From: Anita Gardner
Sent: 21 March 2018 17:54
To: Juan Baeza
Subject: FW: M/123/17/HH and M/133/17/PL - Little Thatch, 93 Middleton Road

Dear Mr Wilson,

DRAWING 105
PROPOSED AND EXISTING
STREET ELEVATION
1:250
APRIL 2018

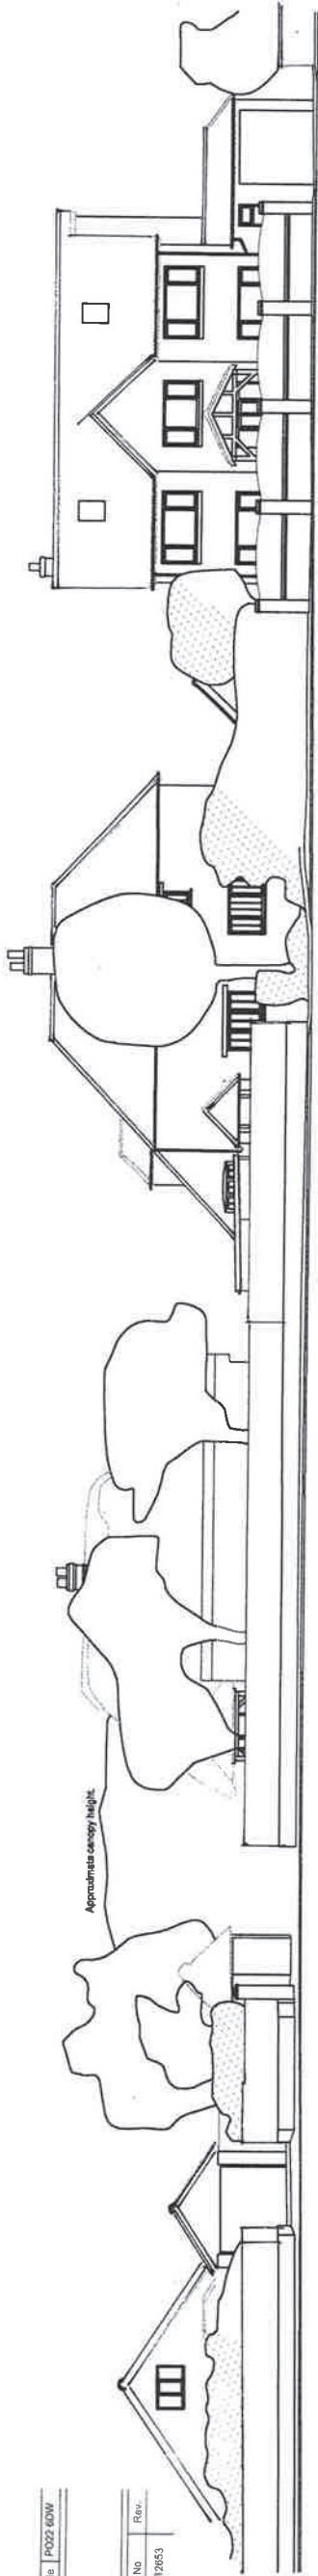
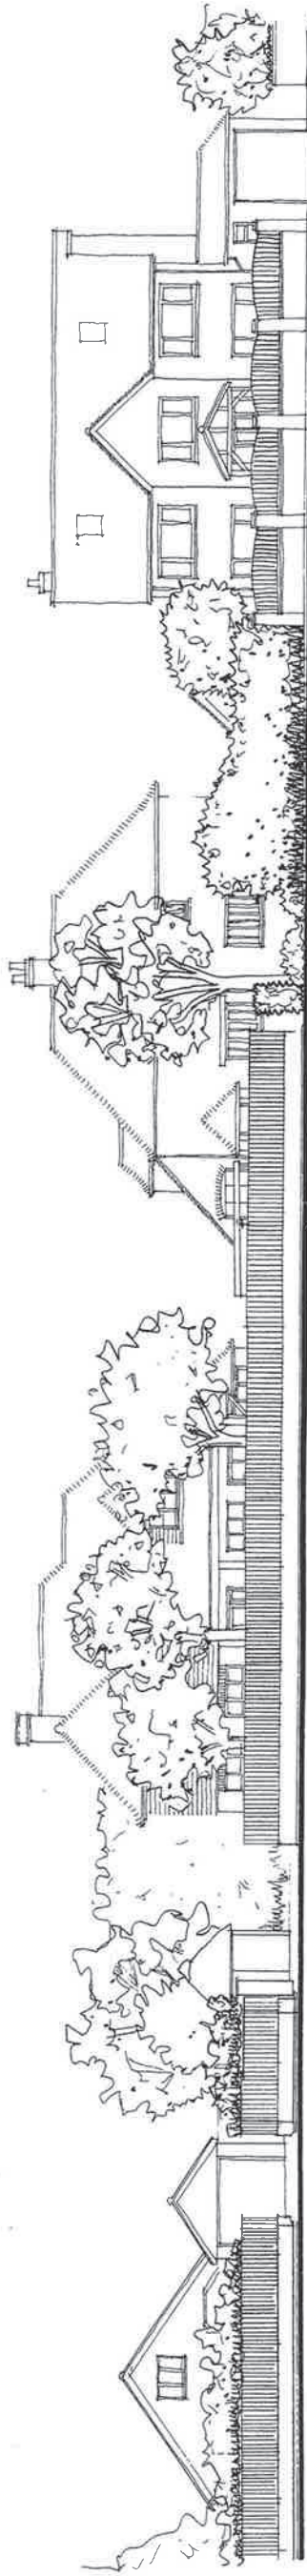
A plan is required to show the street scape so that it highlights your property in relation to neighbouring properties and a daylight/sunlight report/drawing in support of the application.

LOCATION AND BLOCK PLANS

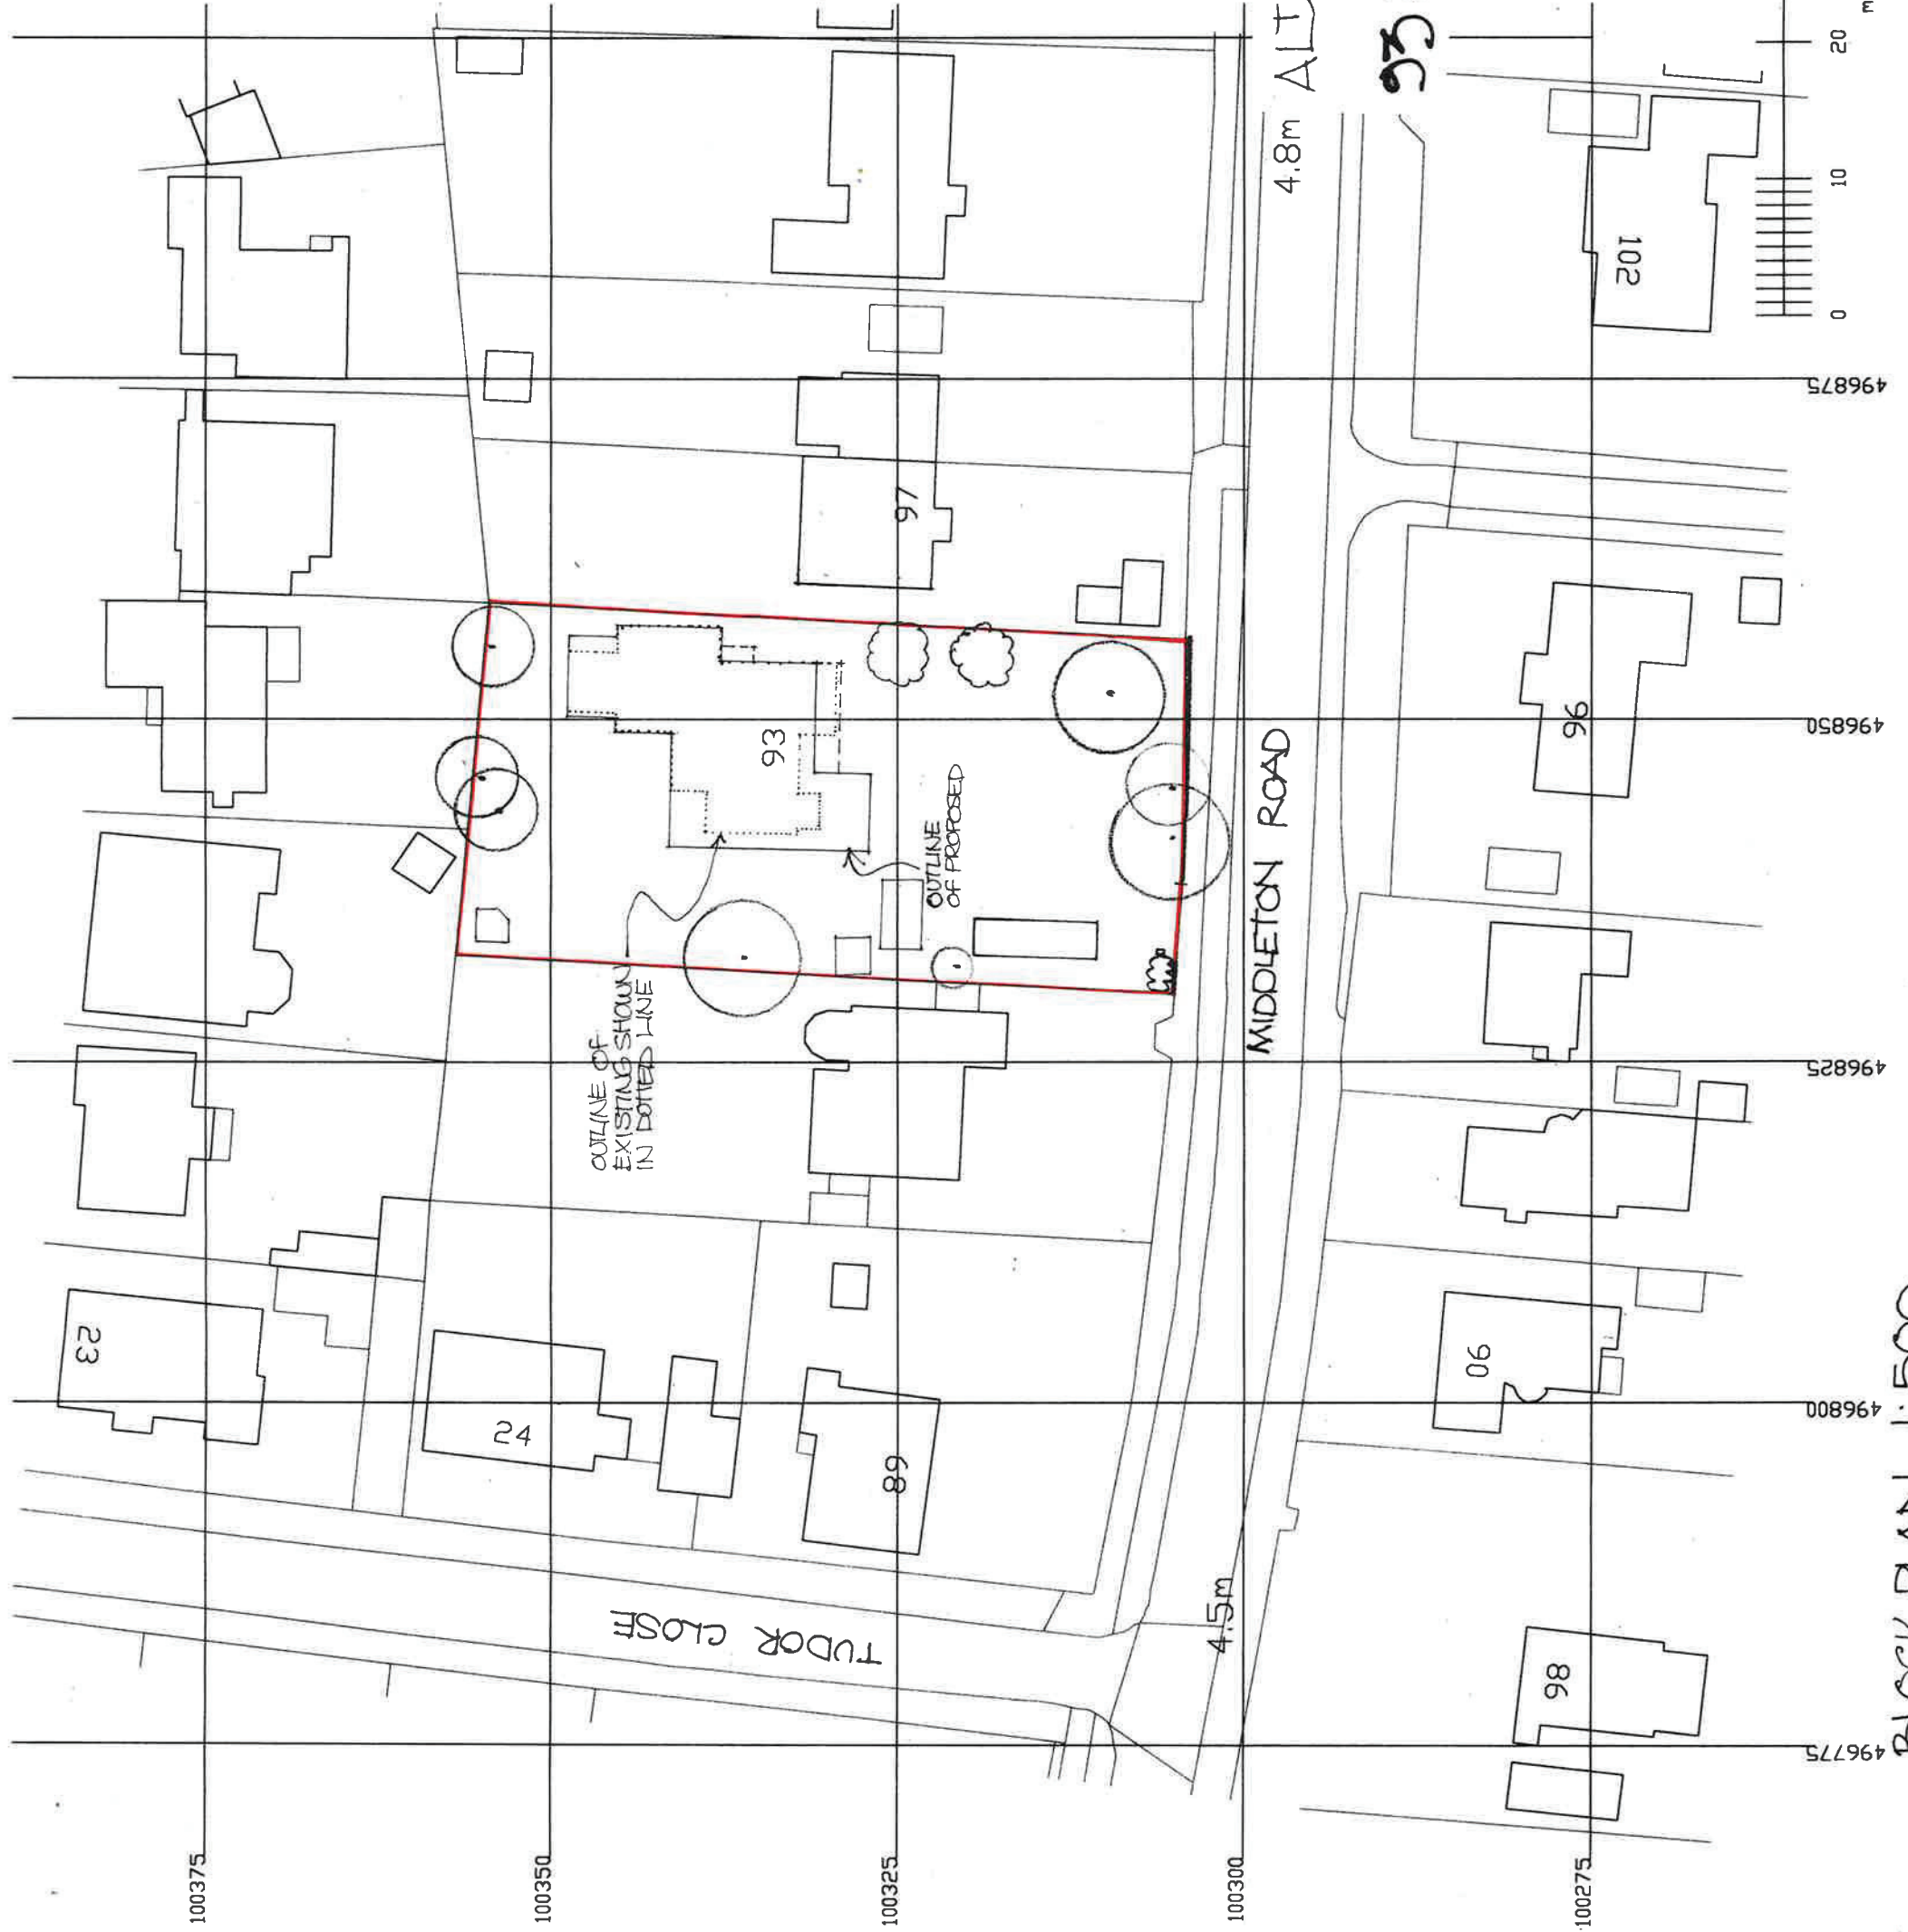
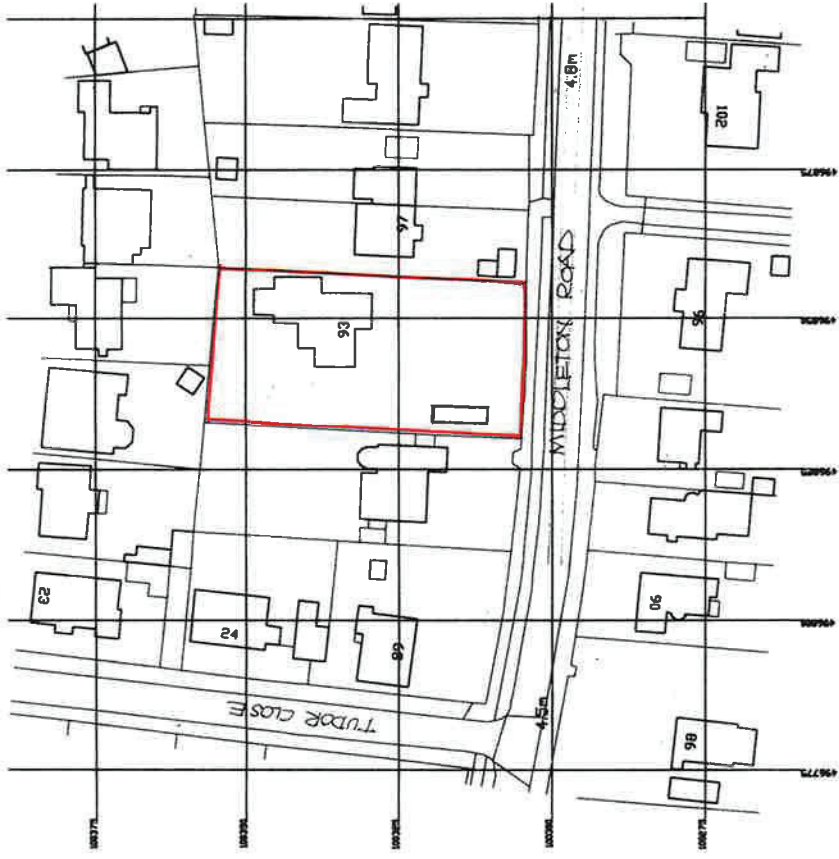
The plans that you submit within the next two weeks will need to have professionally surveyed your property and your neighbours numbers 91 & 97 as they are currently built. This way the Location and Block Plans will show all these properties and I can confidently use them to accurately determine and highlight distances to the various boundaries/elevations. The plans (elevations and floor plans) submitted should be in existing and proposed form. They should include the existing first floor layout plan which is currently excluded from the application. They should be in colour and show all the detail that you are proposing for the extension for example detailing around the proposed windows/doors, tile hanging, highlight design features that draw on features found the locality., etc.
